October 27, 2017

**RE: ADU14-003, CAO17-005, SHL17-007-004, Second Review Letter  
Land Use Applications for proposed home, ADU driveway and retaining wall  
construction within a steep slope along the shoreline for the Lady Bug Trust.  
DEV17-009 Impervious Surface Deviation Application has been withdrawn.**

RE: ADU17-003, CAO17-005, SHL17-007, SUB17-004 Second Review Letter  
Land Use Applications for proposed home, ADU, driveway and retaining wall construction within  
a steep slope along the shoreline for the Lady Bug Trust

1 retaining wall plan
1/16" = 1'-0"

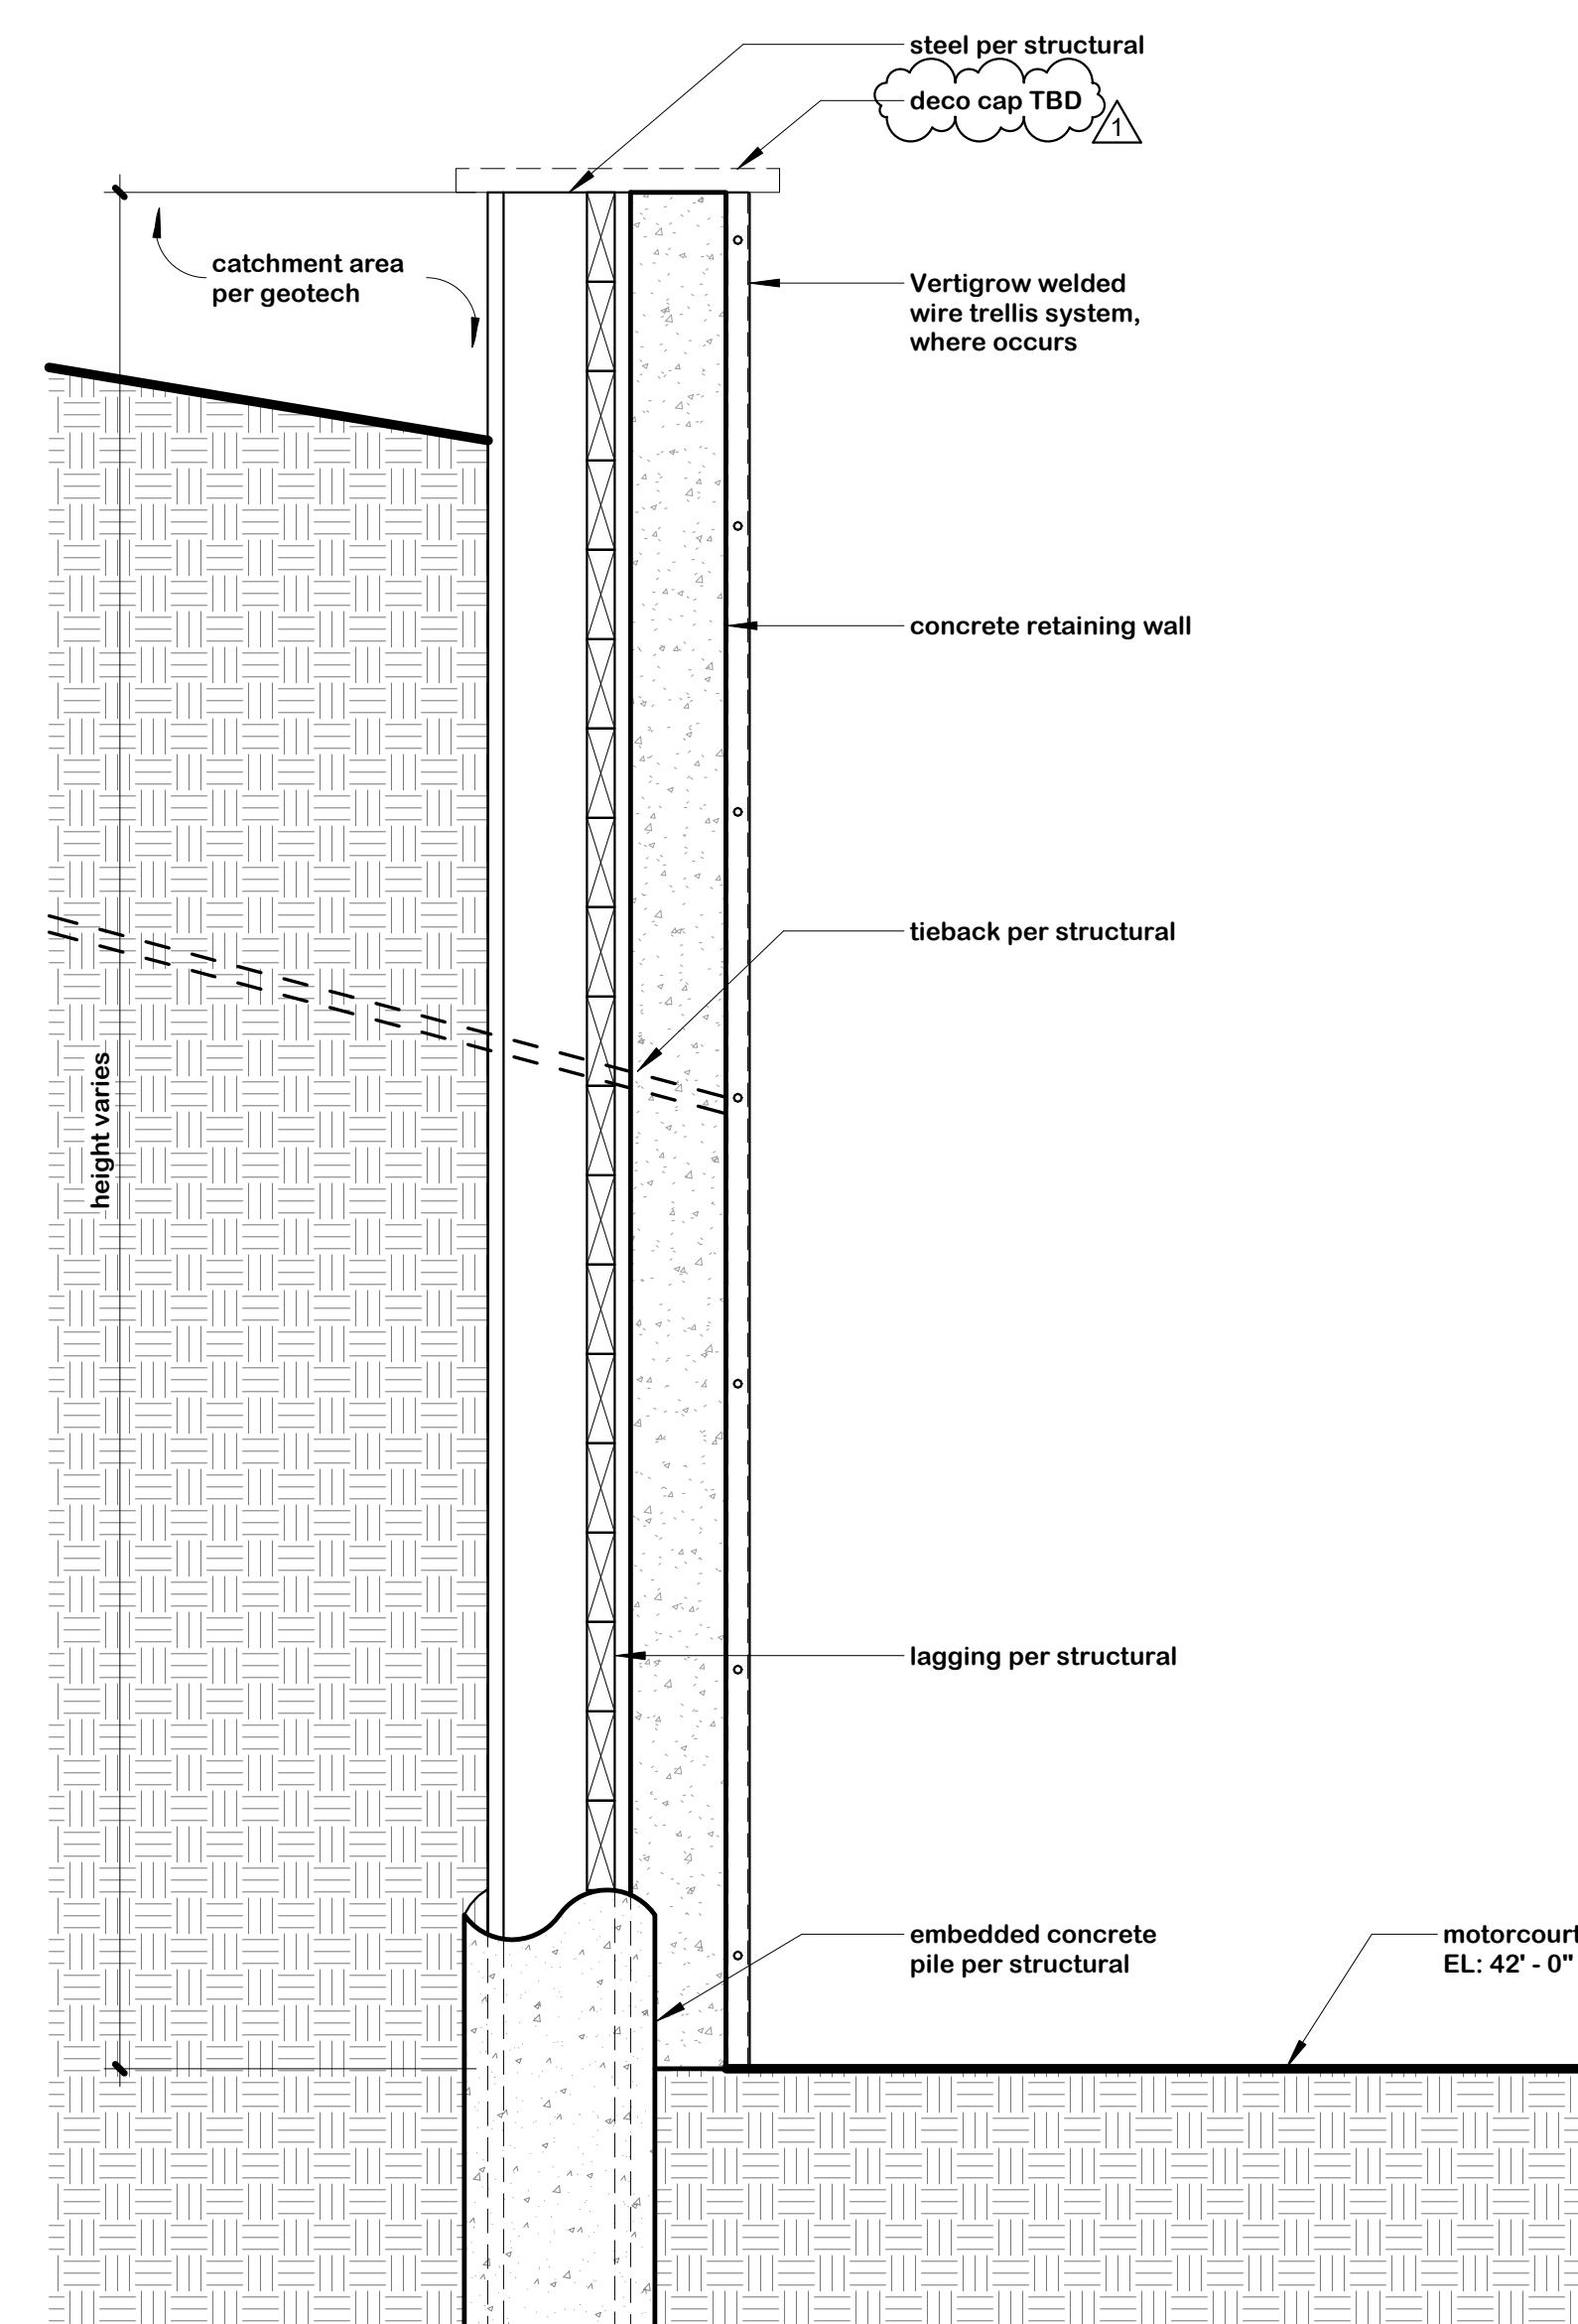
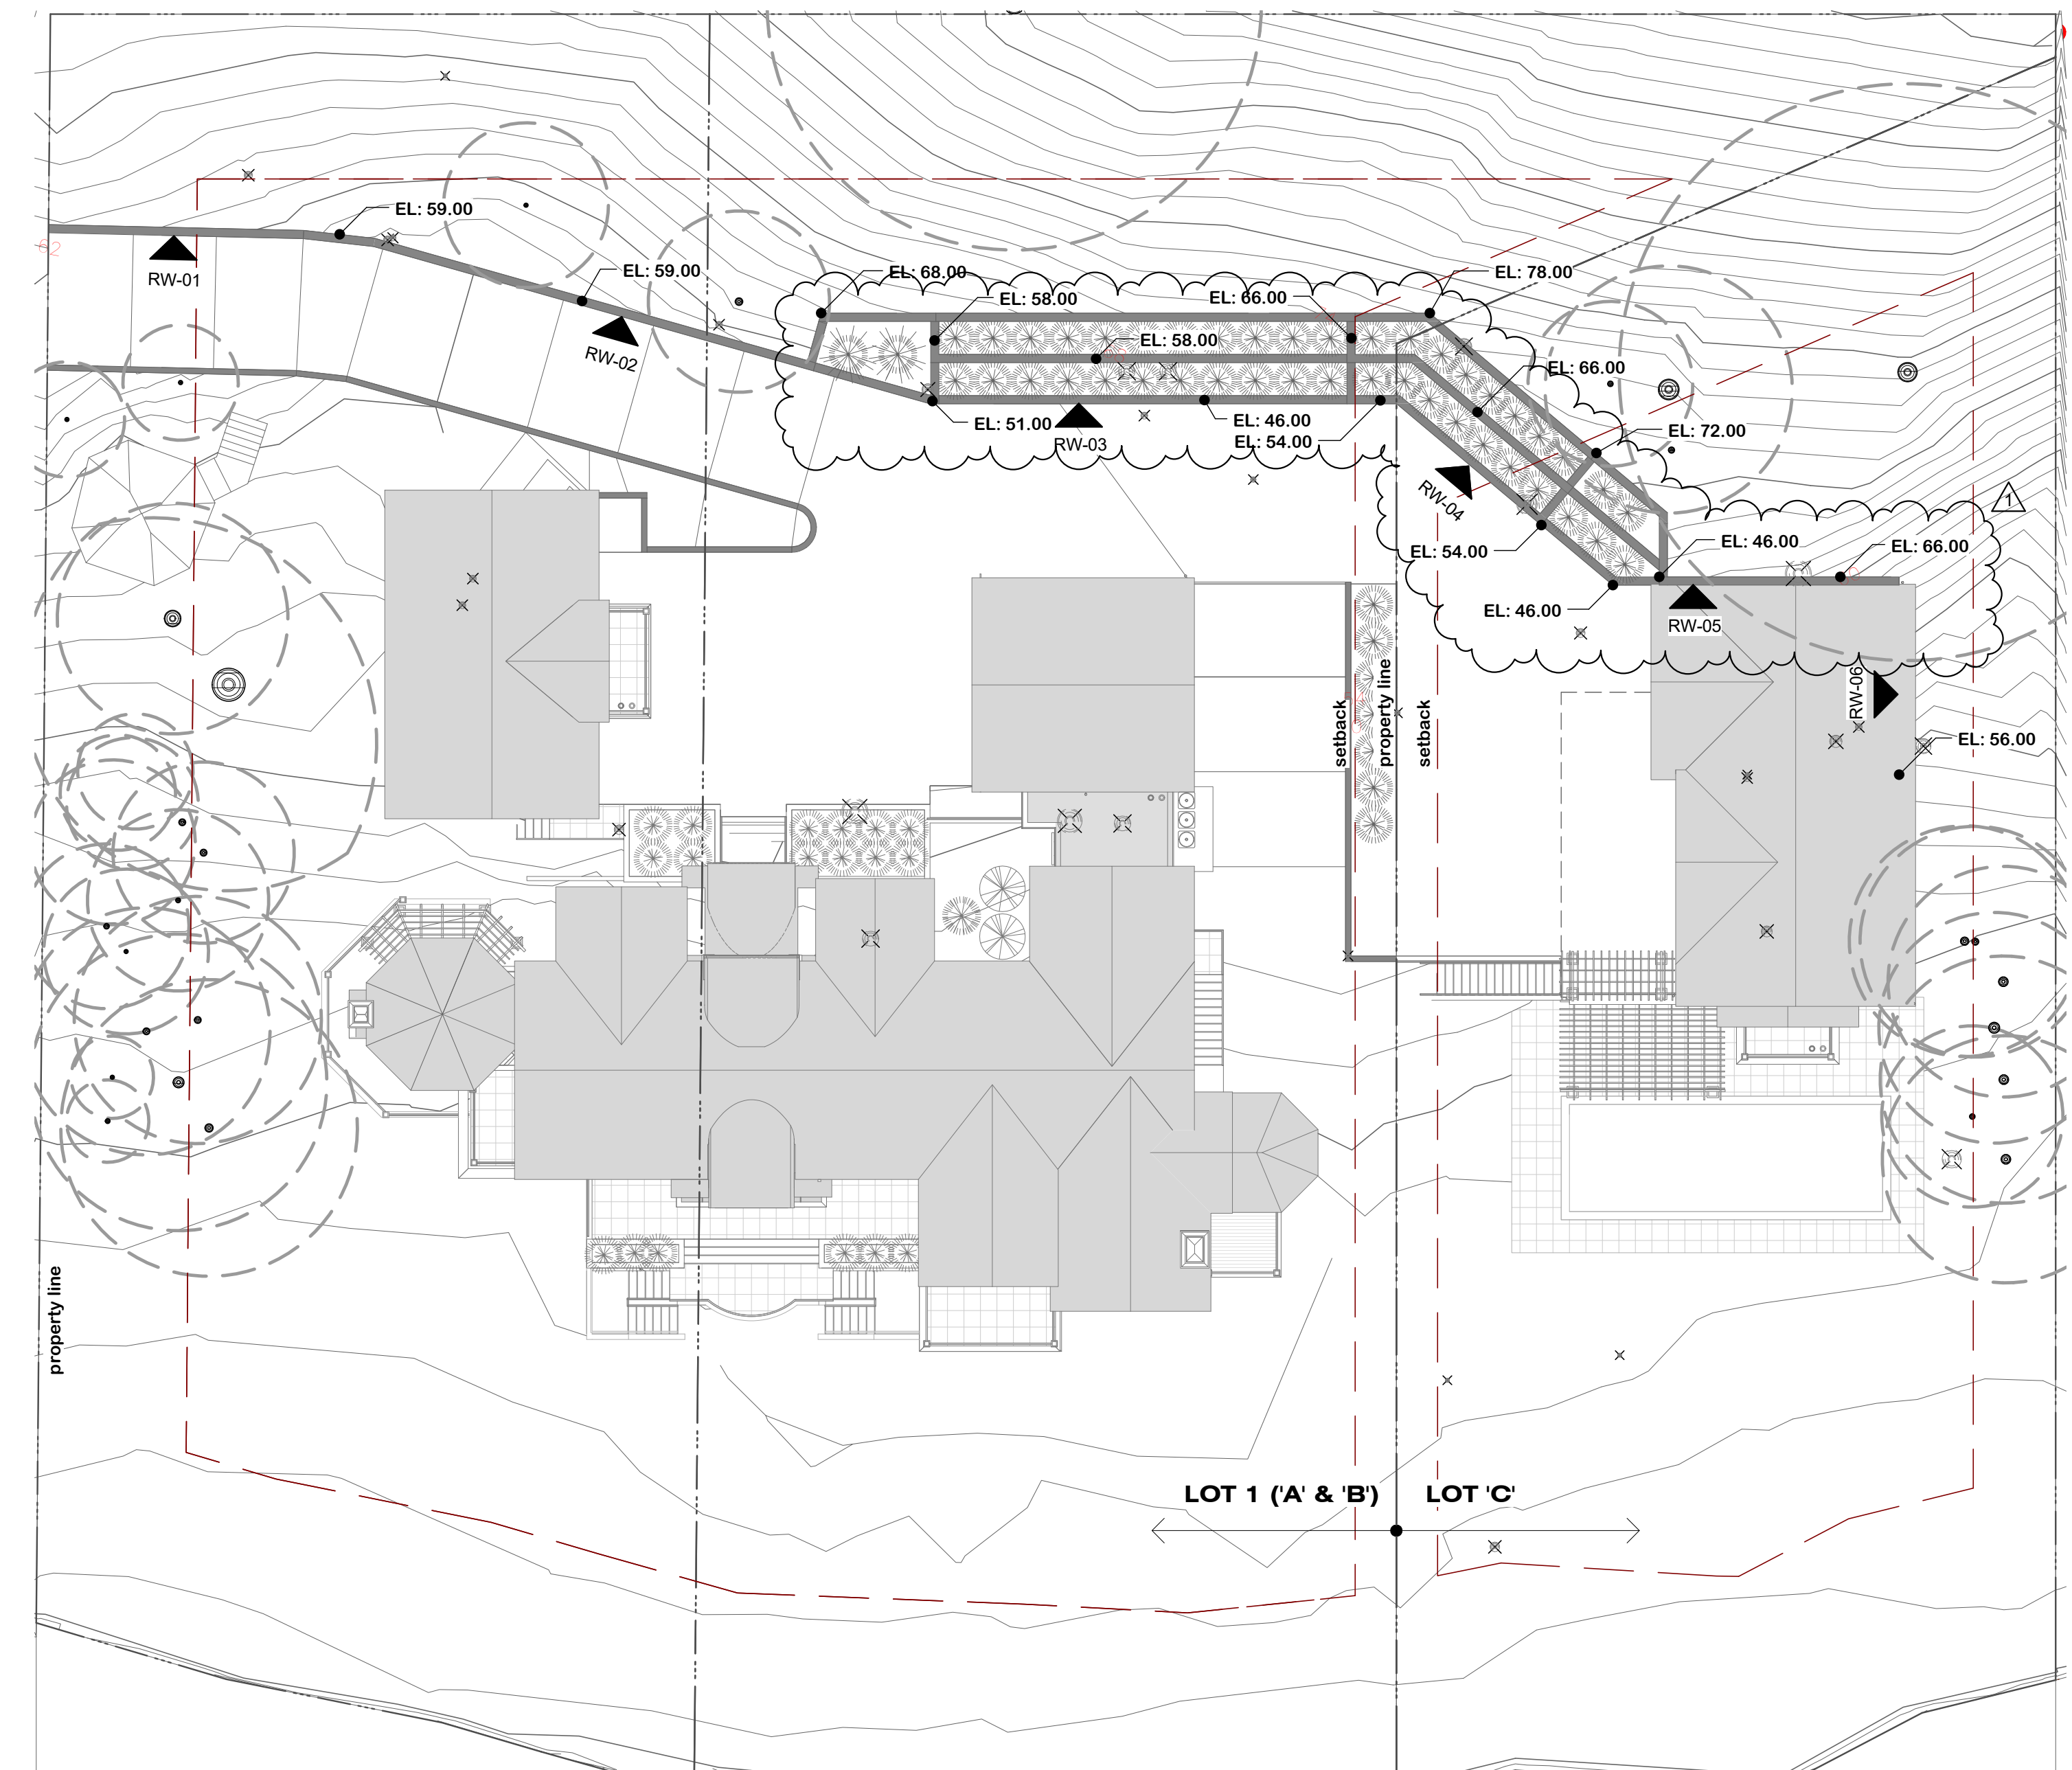
7. *On Sheet A2.4, please verify that the proposed retaining walls within the required side setbacks meet our height requirement set forth in MICC 19.02.050. The maximum height is 144 inches for cut slopes, and the proposed retaining wall 03 is in question at a maximum height of approximately 29 feet 9 inches. In addition, with the proposed code update, the maximum height of the retaining wall outside of the required setbacks is 17 feet. Please consult with your Geotechnical Engineer and Don Cole (Building Official) about the design of the retaining wall, possible options include stepping the retaining wall and/or raising the driveway from the current proposal (still must meet maximum driveway grade of 20%).*

**Please see the revised shoring wall design on sheet A2.4. The proposed retaining wall complies with the new Residential Development Standards. The maximum height of retaining wall segments are less than 17'-0", except within the side yard setbacks where a maximum height of 12'-0" is maintained.**
